From: Laura Gibbons
Sent: 19 October 2018 09:43
To: [REDACTED]
Cc: Zac Denton; 'Robert Paterson'
Subject: RE: WA/72/18/HH - Pre-commencement conditions

BLOCK PLAN (1:500)

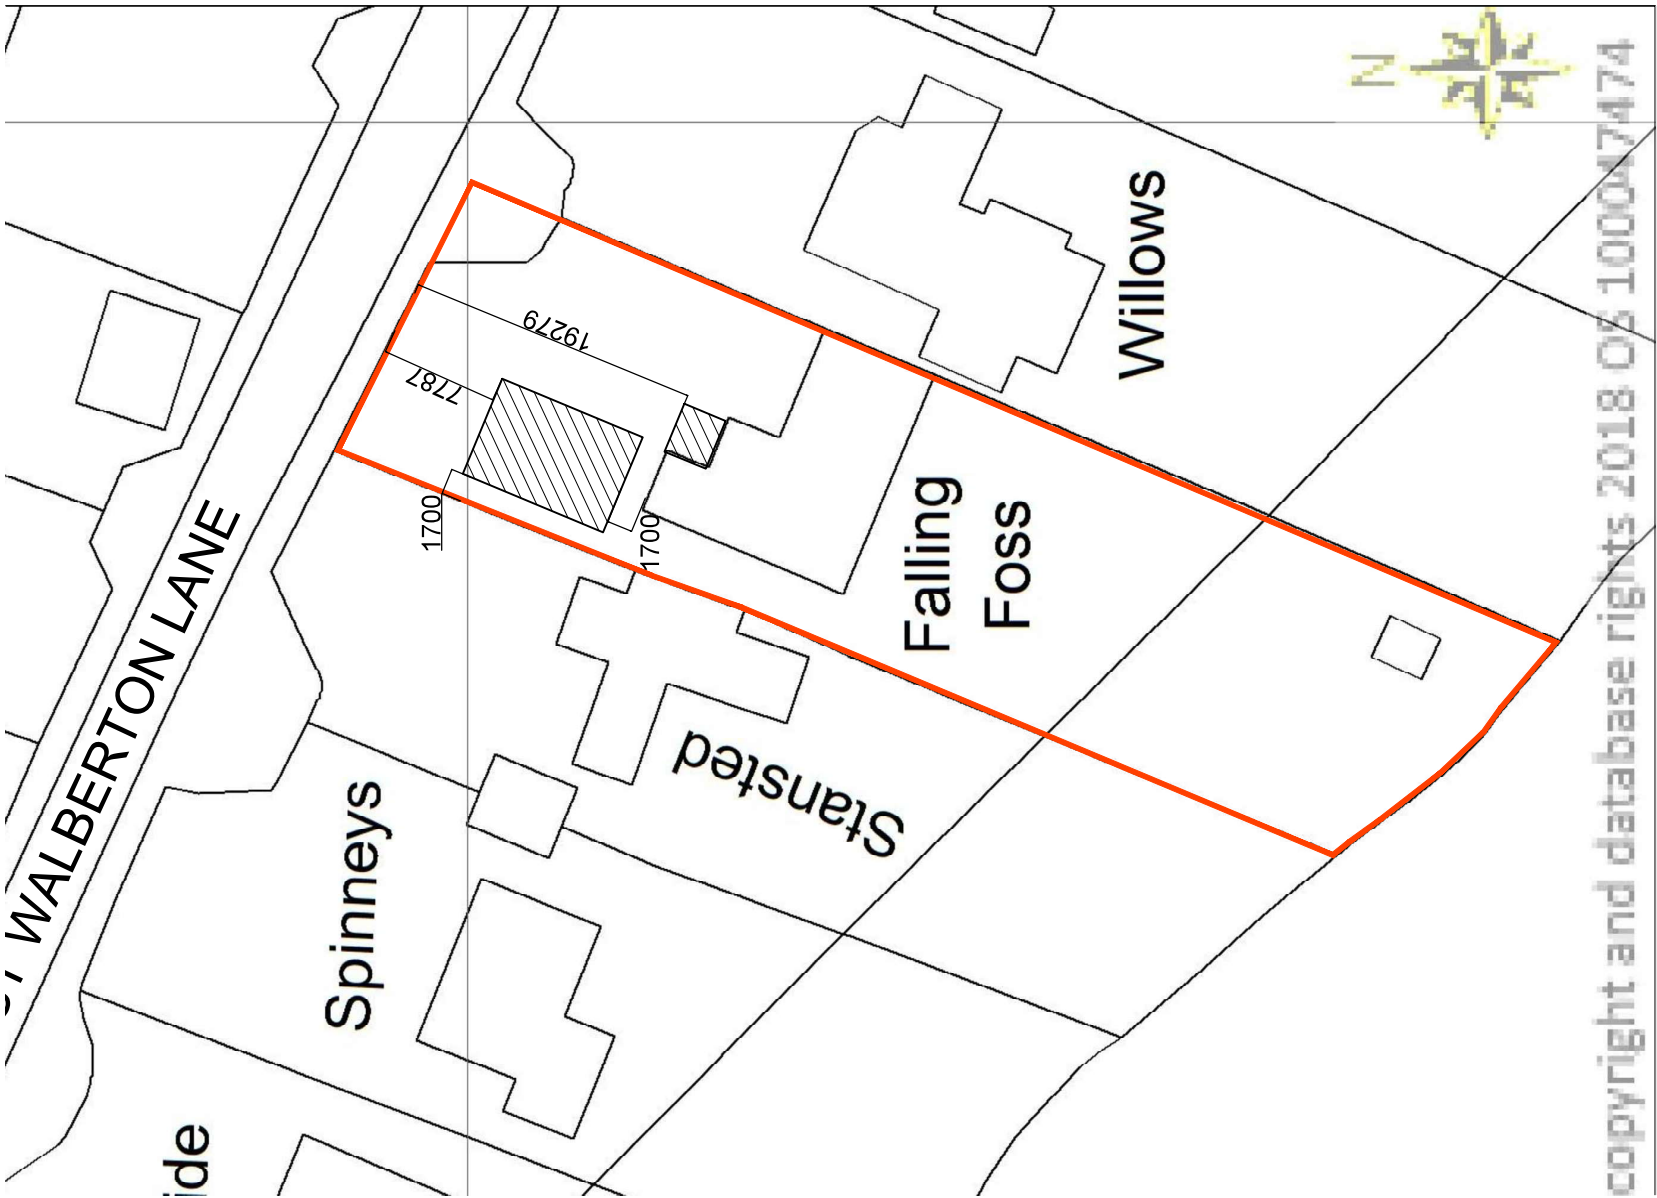
Groundwater levels are currently low. Monitoring should be completed to determine the highest groundwater levels taking account of seasonal variations, this is in line with building regulations. Groundwater levels should be higher in January, however it is weather dependant. I could be insisting on waiting and seeing what the weather does and consequently monitoring could be pushed back to March; but I have decided on this occasion that we will allow the tests to be completed in January.

It is crucial that the testing is completed before development occurs. Space for soakaways, attenuation tanks etc. is essential and will be highly dependent on the testing. The level at which the surface water drainage system, including rodding eyes goes in at is also dependant on the testing. Therefore, it is inappropriate for development to occur before the testing is completed and the surface water drainage design is approved.

From the photo you have sent over I can see that no rainwater pipes are present on the existing structure, these will be required on the proposed structure. Consequently rainwater off of the new structure will be concentrated. This demonstrates that it isn't just the size of development that needs to be considered.

"We will require winter testing to be completed. Without this it is not possible to know if the surface water drainage will be able to sufficiently drain the development and flood risk could be increased elsewhere as a result. Groundwater could rise within the infiltration system and inundate it with groundwater. West Walberton Lane has historically flooded and therefore drainage needs to be carefully designed.

The testing should be completed some when between October and March when groundwater levels are highest. We know that groundwater levels are currently near their lowest levels in the area as a result of the dry summer. We would therefore wish for the applicant to discuss an appropriate time for the tests to be completed with us. The requirements for this are based on CIRIA and Building Regulations requirements for soakaways to be cited above maximum groundwater levels taking account of seasonal peaks.

I also strongly suspect that 1m3 will be insufficient volume as a result of the underlying soil conditions.

Groundwater monitoring should be completed before infiltration tests to confirm the appropriate depth for the infiltration tests to be carried out. I have attached our drainage guidance notes which have some further information and I am happy to speak to the applicant should they have any further questions."
